Appeal Decision

Appeal Ref: APP/R5510/W/22/3307666

73 Victoria Road, Hillingdon, Ruislip HA4 9BH

- The appeal is made under section 78 of the Town and Country Planning Act 1990 against a refusal to grant planning permission.
- The appeal is made by Pershing Properties Limited against the decision of London Borough of Hillingdon.
- The application Ref 76505/APP/2022/586, dated 10 February 2022, was refused by notice dated 20 April 2022.
- The development proposed was originally described as the conversion of the existing loft and building over the outrigger airspace to create a new one bedroom flat at second floor level.

REAR ELEVATION

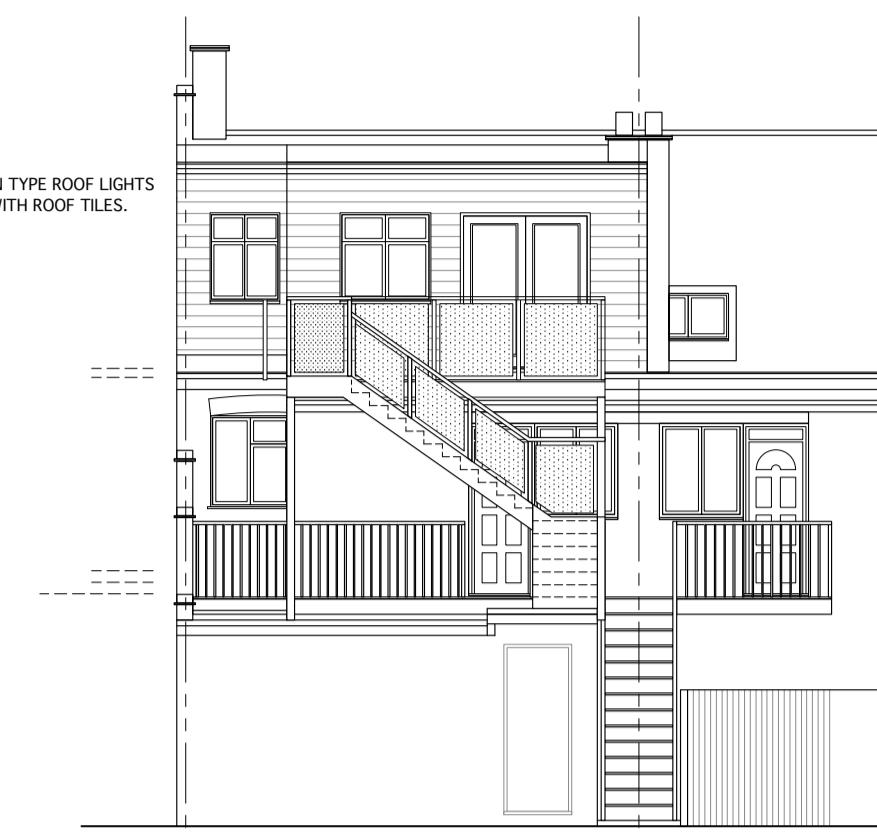
the length of the projection to the rear, and its elevated height, it would appear an unduly bulky structure, subsuming most of the rear roof slope. Even with matching materials, the shape, size, and elevated location would not harmonise with the host dwelling and the row of properties that form part of this terrace.

5. There are external staircases at present to the rear of the terrace. However, the proposed staircase would reach the second floor level and, at this height it would be a highly prominent discordant feature. Moreover, the combination of the existing, and proposed staircase, would result in a significantly cluttered appearance, blocking views of windows, to the detriment of the appearance of the façade. In this regard, the degree of visual clutter within the rear of the terrace group does not justify adding to the clutter at a more prominent elevated position.

SECOND FLOOR PLAN

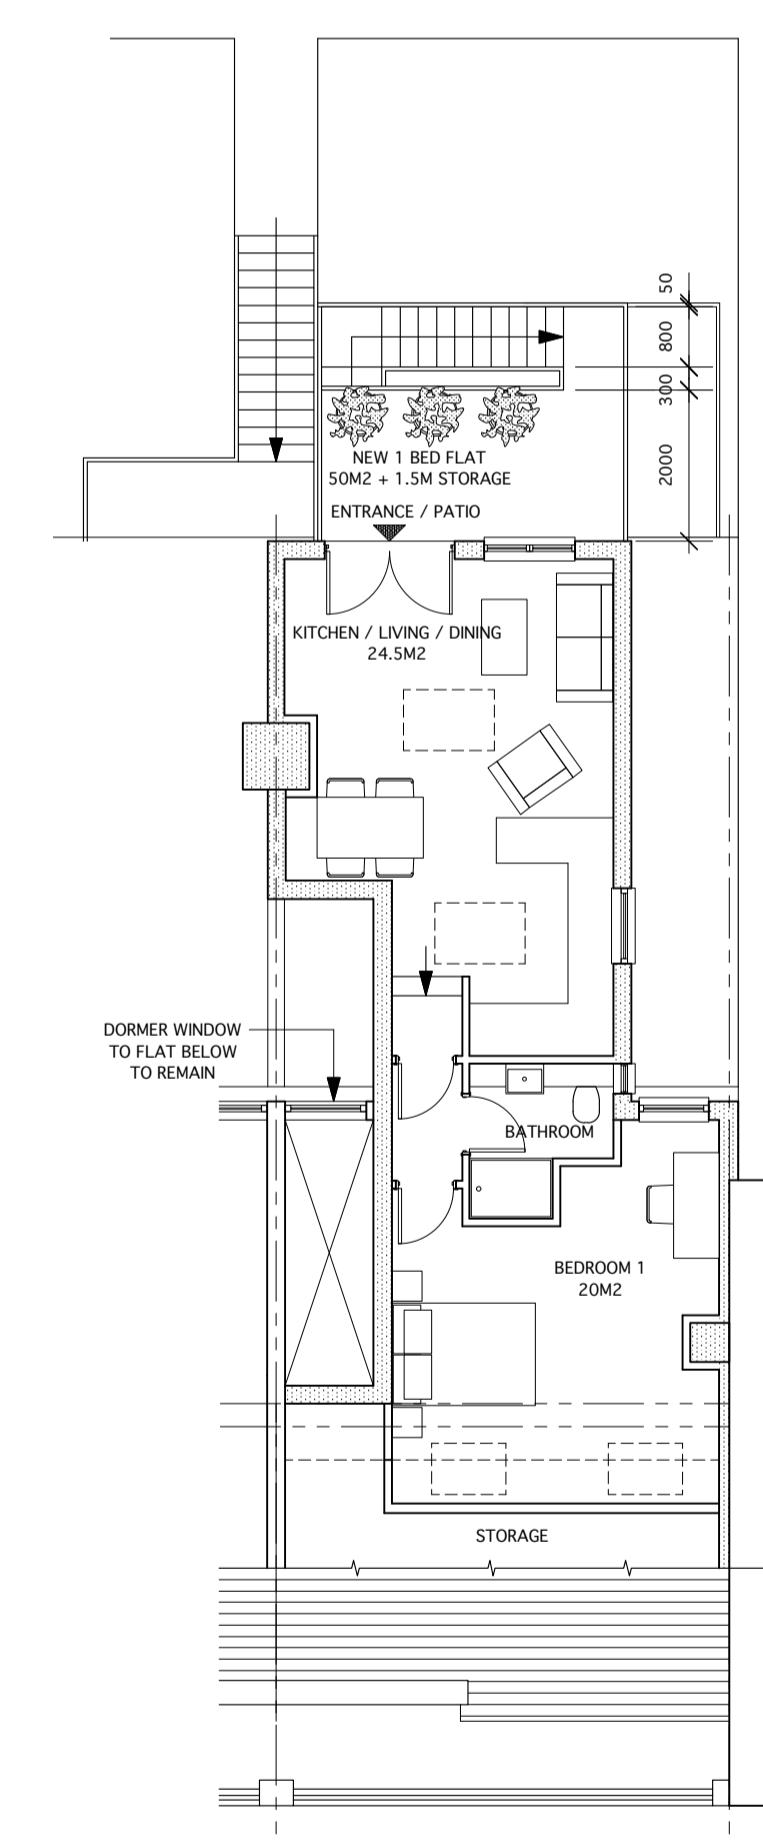
15. The proposed bedroom 1 would be served by a combination of two roof lights and a small window. This window would be positioned immediately adjacent to the long projecting built form proposed and in close proximity to the more modest but projecting built form of No 75a. The bedroom would, because of the design, in my view, have inadequate outlook and access to natural light.

16. The external space falls significantly short of the Council's requirements of 20m², as set down in Table 5.3 of the LP2. Private outdoor amenity space provides a different and important function, to public spaces such as the nearby Shenley Park. In this regard, the location of the park within walking distance does not justify a departure from the requirements set down within Policy DMHB18 and Table 5.3 of the LP2. The proposed external space is small, and given it would be used as the access to the property as well, provides little meaningful useable amenity space. The lack of privacy that would ensue from its elevated exposed nature, although not determinative, adds to my concerns.
